FIVE ESTUARIES OFFSHORE WIND FARM

SCHEDULE OF CHANGES TO THE DRAFT
DEVELOPMENT CONSENT ORDER
(TO REVISION I, DEADLINE 8A)

Application Reference	N/A
Application Document Number	N/A
Revision	N/A
APFP Regulation:	N/A
Date	March 2025

APFP Regulation: 5(2)(k)
 Sheet No: 10 of 20

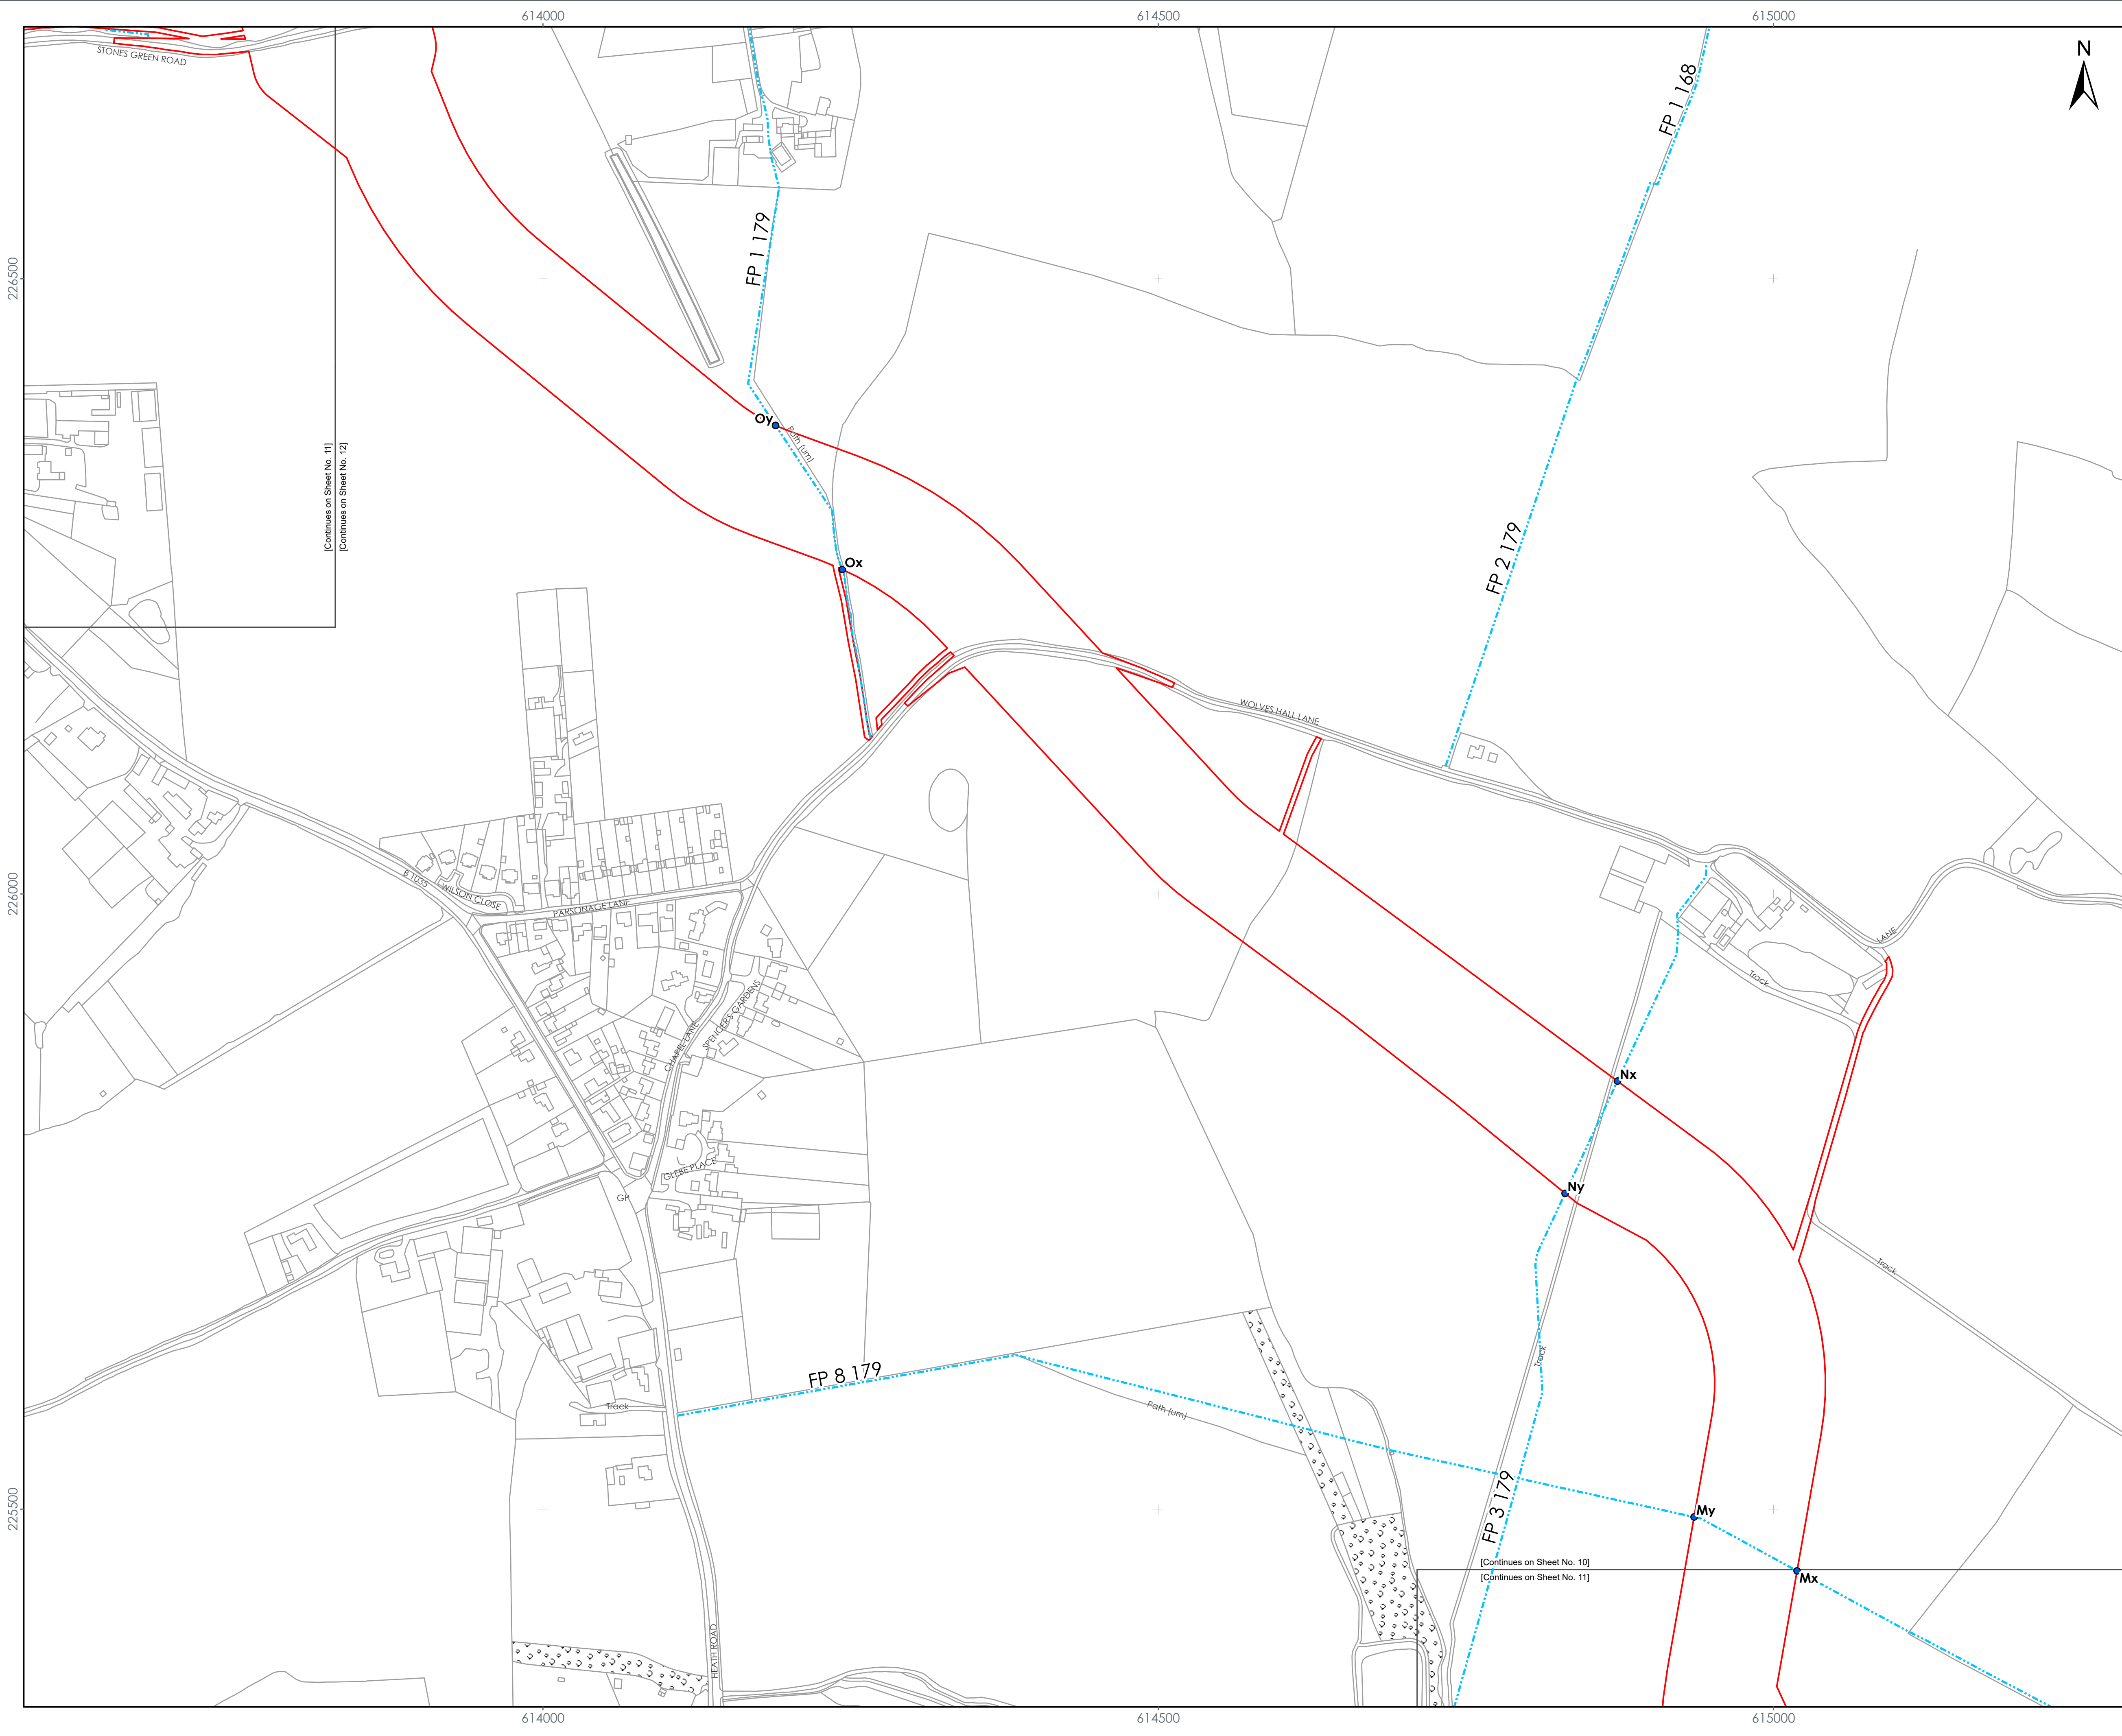
Schedule 4, Part 1, Rights of way closed or restricted	FP22 179 and FP17 179 Between points Lw and Lx and Ly to Lz as shown on sheet 10 of the temporary closure of public rights of way plan	Correction of insertion to correct location

APFP Regulation: 5(2)(k)
 Sheet No: 11 of 20

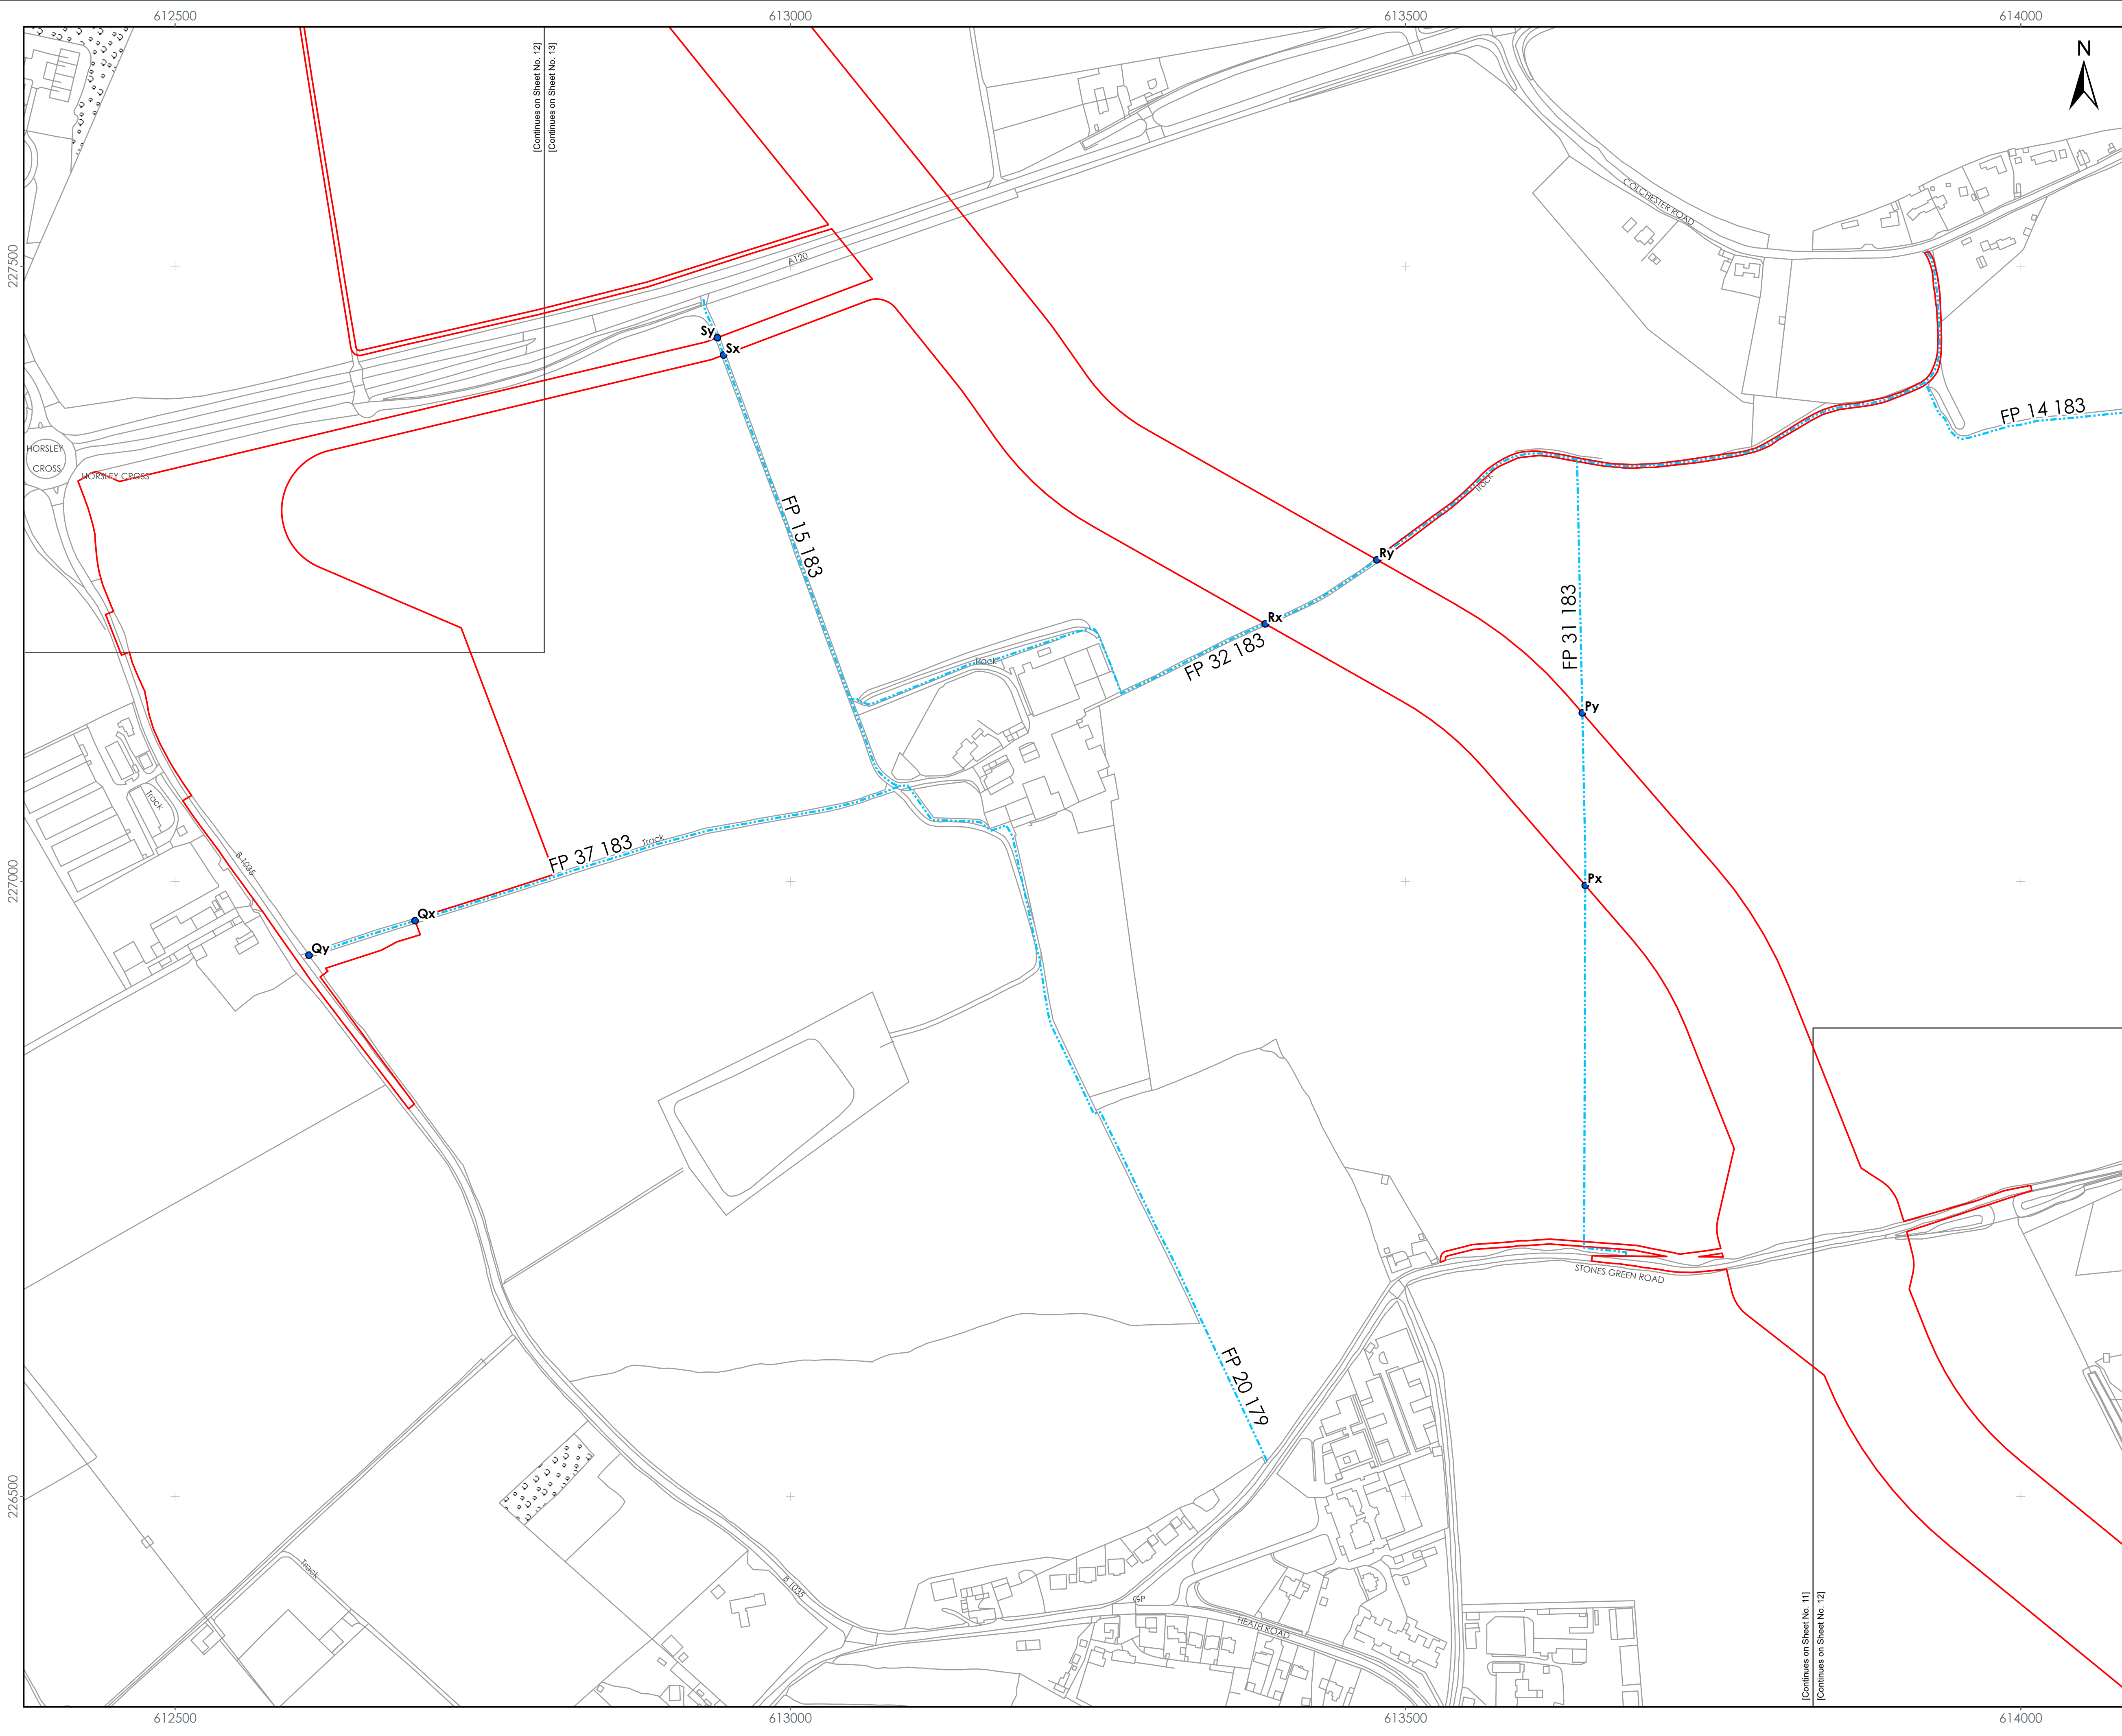
FP25 179 and FP17 179	Between points Nx and Ny as shown on sheet 11 of the temporary closure of public rights of way plan	
Schedule 9	Amendment of Part 3 For the protection of the Environment Agency		Following agreement of the provisions
	Amendment of Part 12 For the protection of Anglian Water		To narrow the differences between the parties
	Amendment of Part 12 For the protection of Affinity Water		To narrow the differences between the parties
	Addition of Part 14 National Grid Electricity Transmission		Following agreement of the provisions
	Addition of Part 15 Cadent Gas Limited		Agreed provisions omitted in error from previous drafts
Schedule 10, Part 1, paragraph 2(a)	Amendment of disposal maximum volume and addition of disposal sites		To update to consented disposal sites
Schedule 10, Part 2, Condition 6(7)	(7) The undertaker must inform the MMO Local Office in writing at least five 14 days prior to the commencement of the licensed activities and within five days of the completion of the licensed activity.		Amended at the request of the MMO

Schedule 4, Part 2	FP 253 179 <u>and FP17 179</u>	Between points Nx and Ny as shown on sheet 11 of the temporary closure of public rights of way plan		The Applicant has been advised that this PRow has been renumbered by the local authority
Schedule 6	<u>14-018, 14-019, 14-021, 14-022, 14-023, 14-024</u>	Creation, use and restoration of a public non-motorised user path	Work Nos. 12, 12A, 13, 13A, 14, 14A, 14B, 14C, 14D, 15, 16 and 17	Acquisition downgraded acquisition of rights temporary possession only.
	14-035, <u>14-036</u>	Temporary use as a construction compound (Work No. 14C) and construction working area, and haul route to facilitate	Work Nos. 13 and 13A
